Address: 21A Marsland Court Cleckheaton BD19 4DB

Application number: 2024/91260	
What is the application for?:	Variation of condition 2 (plans and specifications) and 35 (removal of permitted
Address of the site or building:	Land at, Merchant Fields Farm, off Hunsworth Lane, Cleckheaton
Postcode:

Type of comment: An objection	
Do you wish your comments to be published on the website anonymously?	No
<p>**Objection to Planning Application Ref Number 2024/91260**</p> <p>To Whom It May Concern,</p> <p>I am writing to formally object to the planning application Ref Number 2024/91260 for the following reasons:</p> <p>1. **House Design Changes and Planning Committee Instructions**: Harron Homes (HH) has proposed to reduce the number of 4-bedroom houses by 10 and increase the number of 3-bedroom houses by 10. This change contradicts the Kirklees Planning Committee's directive, which emphasized the need for 4-bedroom homes. During a publicly held meeting, the Planning Committee Chairman explicitly stated that any alterations to approved plans should be brought back to the committee for approval. However, Kirklees Planning Department has not adhered to this directive, allowing HH to resubm

status: PLANNING
 project: MERCHANTS FIELD CLECKHEATON
 site: SITE LAYOUT
 drawn: QYRB. date: MAY 2019
 checked: RB. scale: @ A0:1:500
 job no: 122. dsg no: 122-PL-01-V

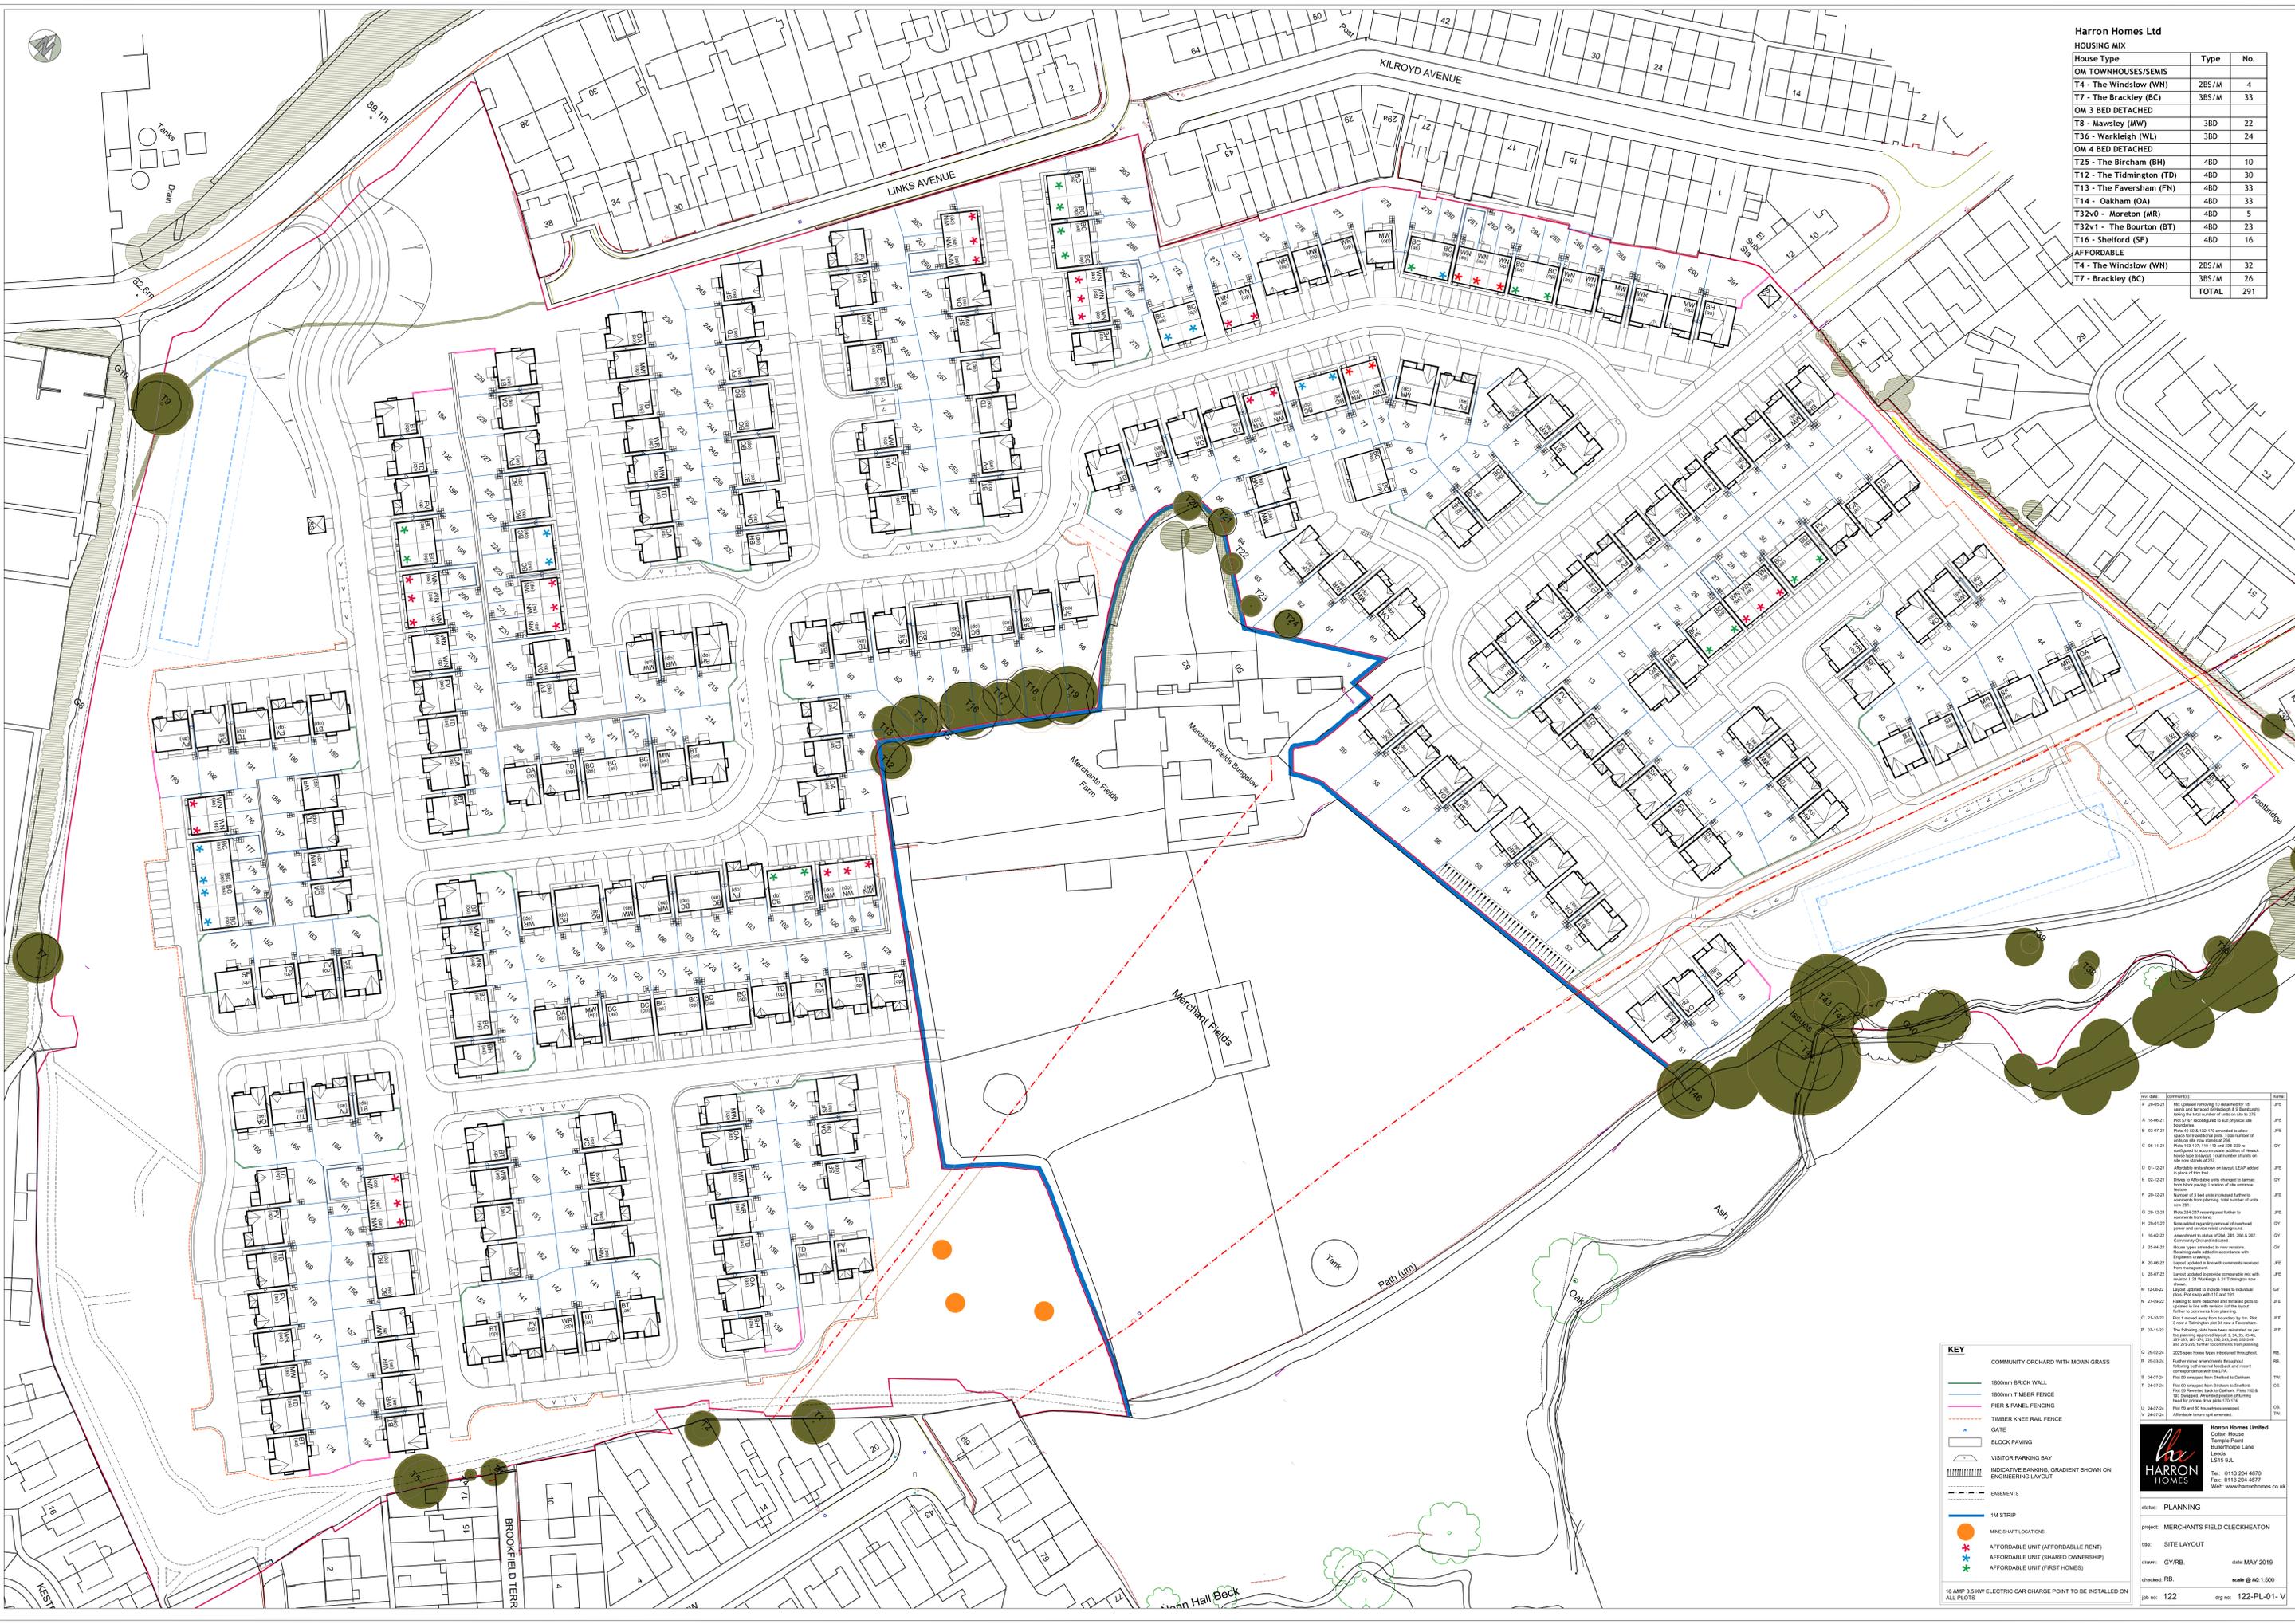
house designs. This reduction in road space was previously raised as a concern due to insufficient turning space for waste refuse vehicles and other large vehicles. Approving a plan that reduces road space could reintroduce this issue, leading to logistical problems and potential safety hazards for residents.

The proposed garden border of the new houses is unacceptably close to the existing bungalow on Merchants' Farm. This proximity is intrusive and exacerbates existing difficulties for refuse, postal, and delivery vehicles turning in this area. The impact on the bungalow's privacy and the practical issues with vehicle movement need to be addressed.

The new plans include picnic areas, benches, and play areas in locations known to flood frequently. These proposals are unrealistic and impractical given the area's history of flooding and landslips. Mature trees have already fallen due to saturated ground, and recent landslips have further destabilized the area. Developing in such a flood-prone and unstable environment is not feasible and poses significant safety risks.
